Development Facilitation Team (DFT) – Review Comments

Project No: PR-2022-006568

Application For: SD-2023-00147-PRELIMINARY PLAT (DHO)

Project Name: 9200 Wilshire Ave. NE

PRELIMINARY PLAT
 VALENTINO ESTATES
 (A REPLAT OF LOTS 4 & 5,
 BLOCK 16, TRACT 3, UNIT 3,
 NORTH ALBUQUERQUE ACRES)
 WITHIN THE
 ELENA GALLEGOS GRANT
 PROJECTED SECTION 17
 TOWNSHIP 11 NORTH, RANGE 4 EAST, N.M.P.M.
 CITY OF ALBUQUERQUE,
 BERNALILLO COUNTY, NEW MEXICO
 JUNE, 2023

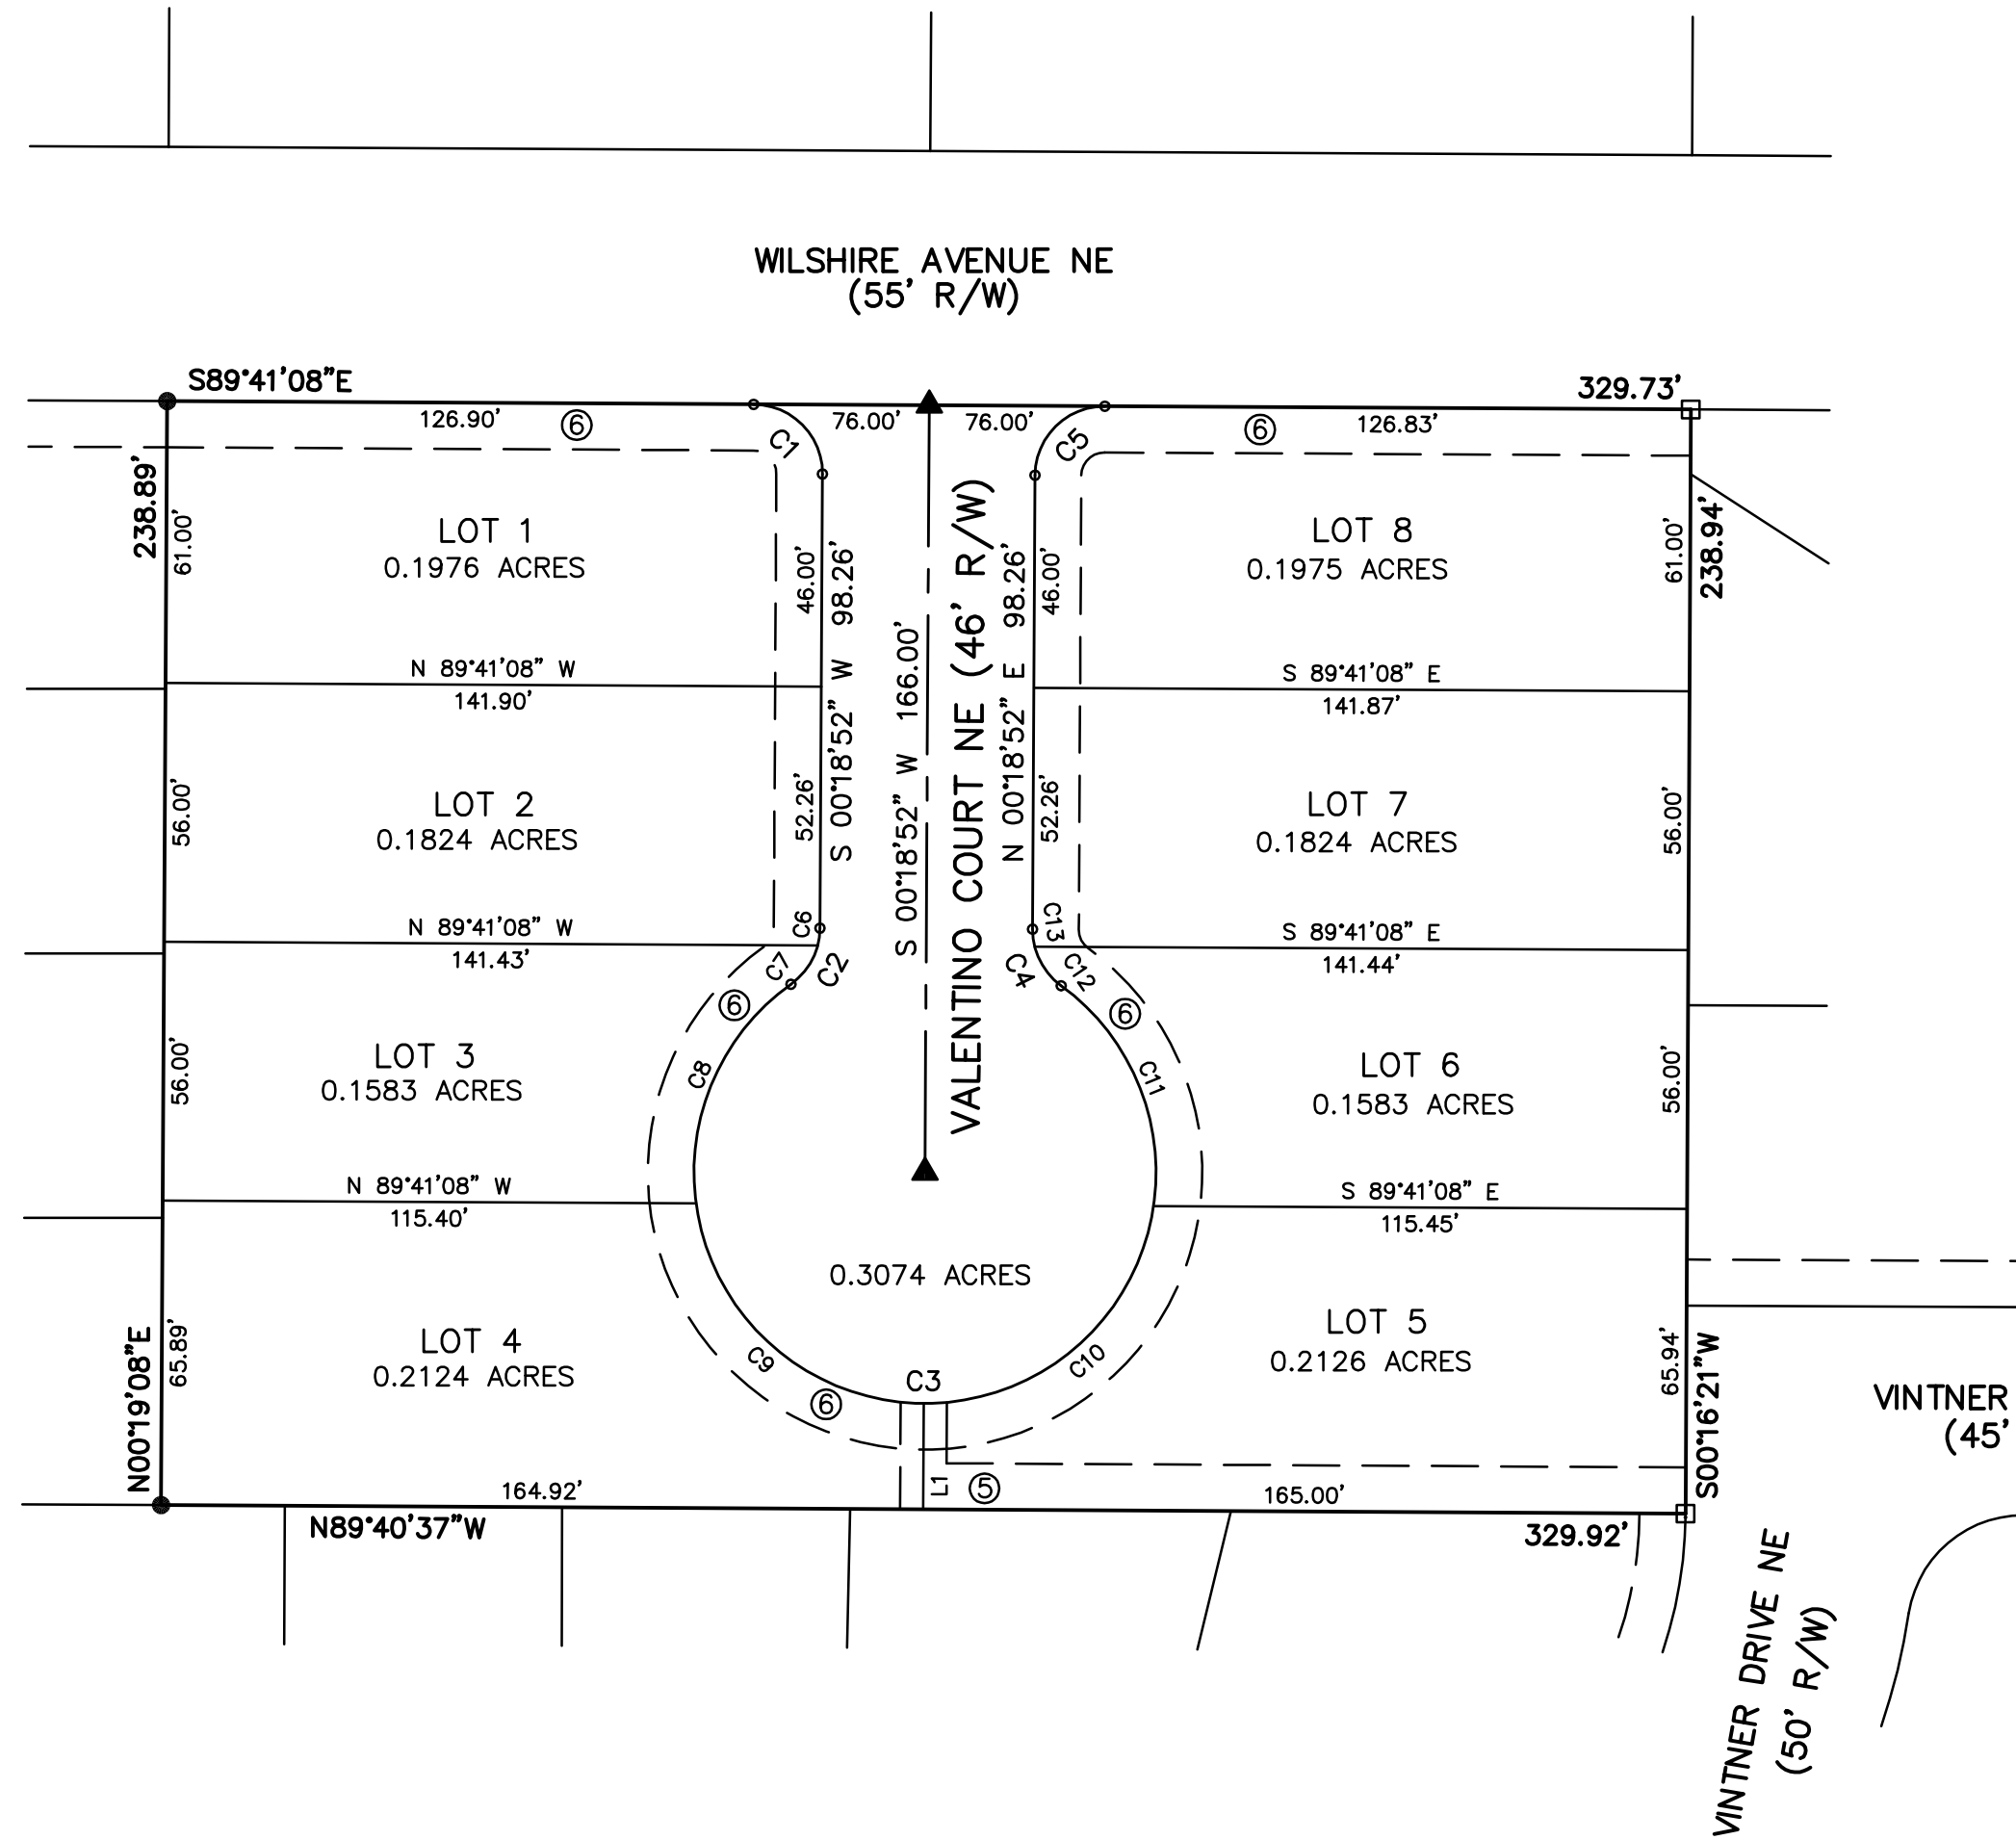
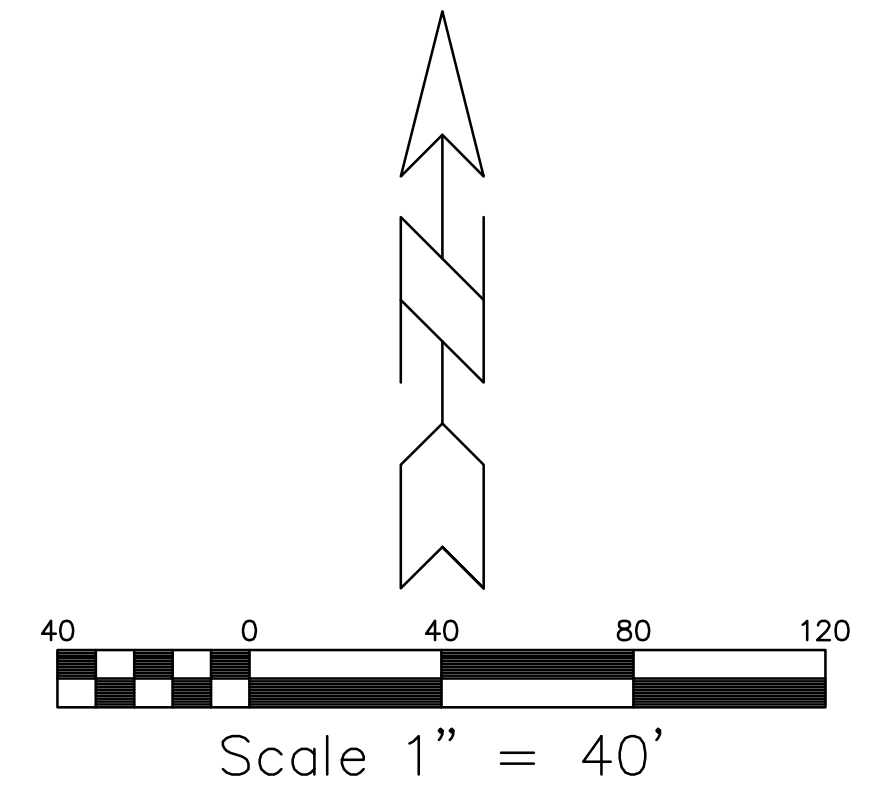
- The roadway/cul de sac depicted on the Plat is considered a new street as well as major infrastructure, which triggered a Major Preliminary application for the platting action as it is considered a new street and/or major infrastructure per 6-6(K)(1)(a)(2 & 3) of the IDO.

- Planning staff defers to the **Hydrology** regarding keyed note #5: public drainage easement on proposed Preliminary Plat.
- Planning staff defers to the **Water Utility Authority** regarding keyed note #6: public utility easement on proposed Preliminary Plat.

CITY OF ALBUQUERQUE
PUBLIC WORKS DEPARTMENT
ENGINEERING DEVELOPMENT GROUP
WILSHIRE PLACE SUBDIVISION
GRADING AND DRAINAGE
GRADING PLAN

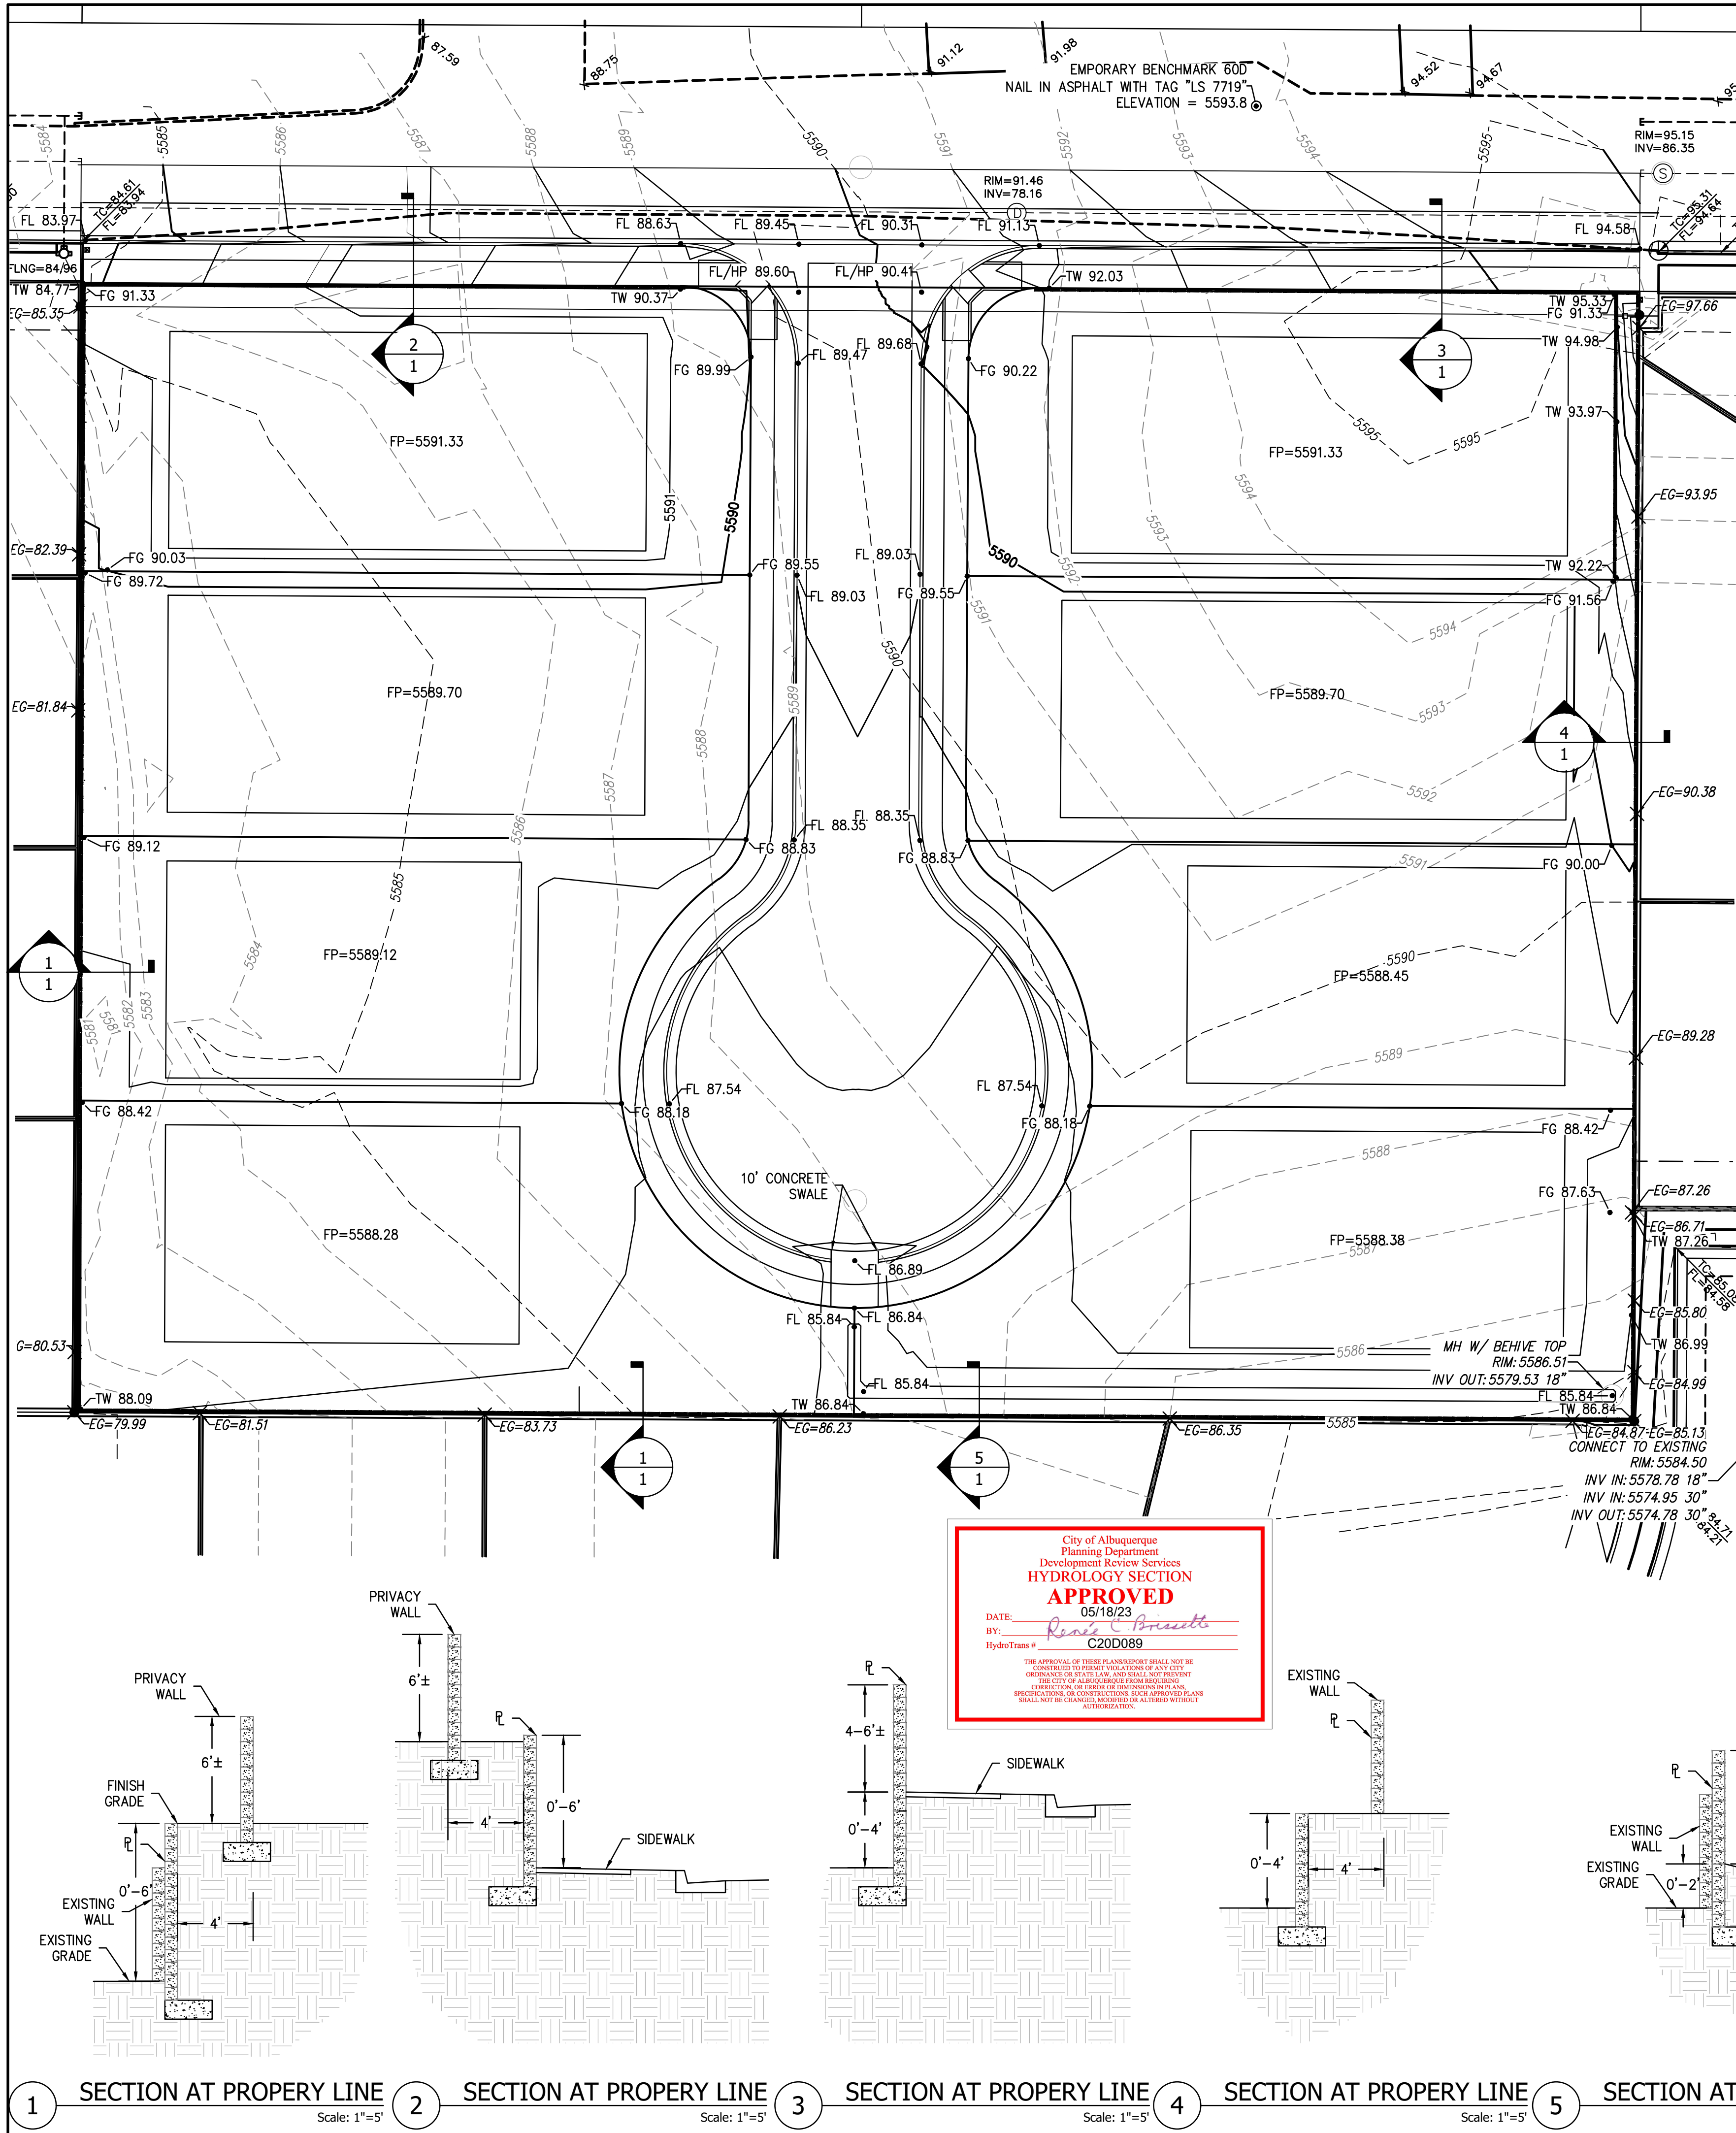
- Note #2 on infrastructure list must state that pond shall be stabilized according to Albuquerque City Specification 10-13, or better.
